O'Connell St Update:

Overview of the O'Connell St Construction Scenarios

| P01.1

21/03/24

Drawing Title	METROLINK - STRUCTURES O'CONNELL STREET STATION PROPOSED STREET LEVEL DESIGN	Drawing Status	S0
Drawing N°	ML1-JAI-SRD-ROUT_XX-DR-Y-02071	Plan Drawing N°	ML-ST 305 F-G1
Scales Original Size A1	1:250	Sheet	1 of 7

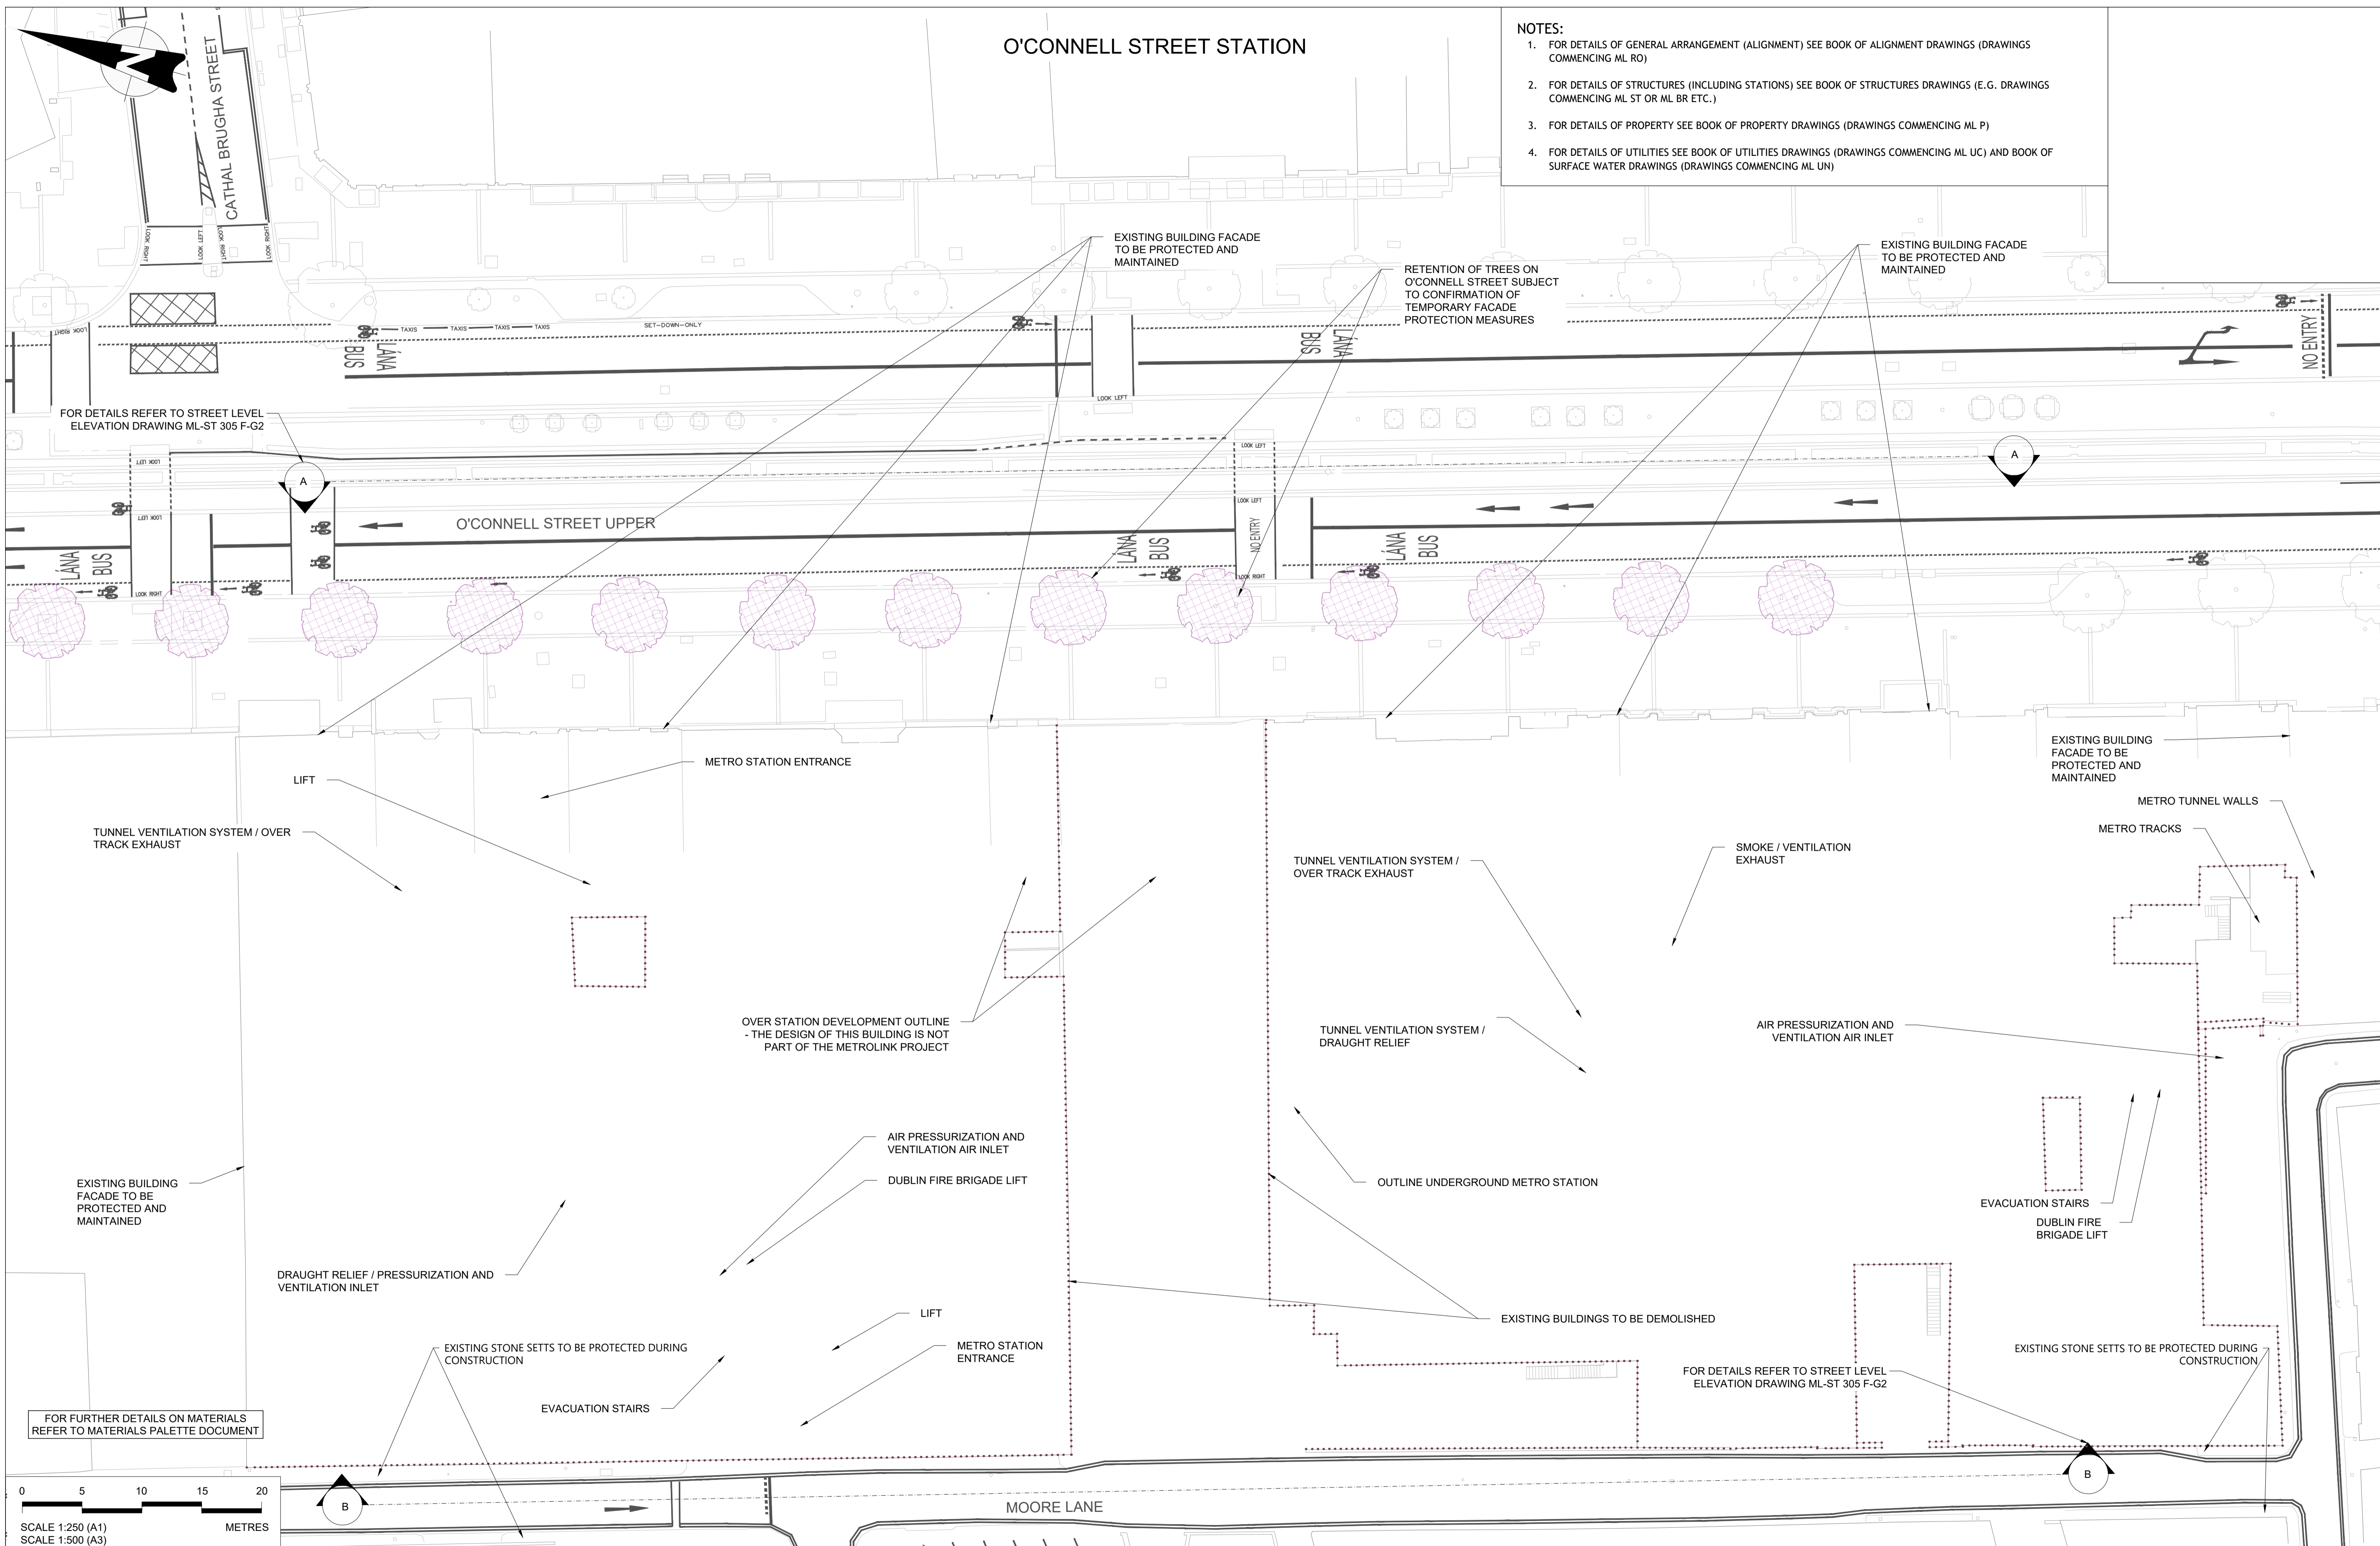
Drawing Title	Drawing Reference	Rev	OSD	Update
1	MetroLink – Structures O'Connell Street Station Proposed Street Level Design	ML1-JAI-SRD-ROUT_XX-DR-Y-02071	P05	Yes	Yes, street and roof level penetrations added.
2	MetroLink – Structures O'Connell Street Station Street Level Elevations	ML1-JAI-SRD-ROUT_XX-DR-Y-02072	P04	Yes	Yes
4	MetroLink – Structures O'Connell	ML1-JAI-SRD-ROUT_XX-	P03	Yes	No

Drawing Title	Drawing Reference	Rev	No OSD	Update
1	MetroLink – Structures O'Connell Street Station Proposed Street Level Design	ML1-JAI-SRD-ROUT_XX-DR-Y-02071	P05	Yes	Yes, street and roof level penetrations added.
3	MetroLink – Structures O'Connell Street Station Street No Oversight Development Street Level Elevation.	ML1-JAI-SRD-ROUT_XX-DR-Y-09017	P01	Yes	Yes, new drawing.
4	MetroLink – Structures O'Connell Street Station Concourse Level	ML1-JAI-SRD-ROUT_XX-DR-Y-02073	P03	Yes	No
5	MetroLink – Structures O'Connell Street Station Mezzanine Level	ML1-JAI-SRD-ROUT_XX-DR-Y-02074	P03	Yes	No
6	MetroLink – Structures O'Connell Street Station Platform and Under Platform Level	ML1-JAI-SRD-ROUT_XX-DR-Y-02075	P03	Yes	No
7	MetroLink – Structures O'Connell Street Station Longitudinal	ML1-JAI-SRD-ROUT_XX-	P03	Yes	No
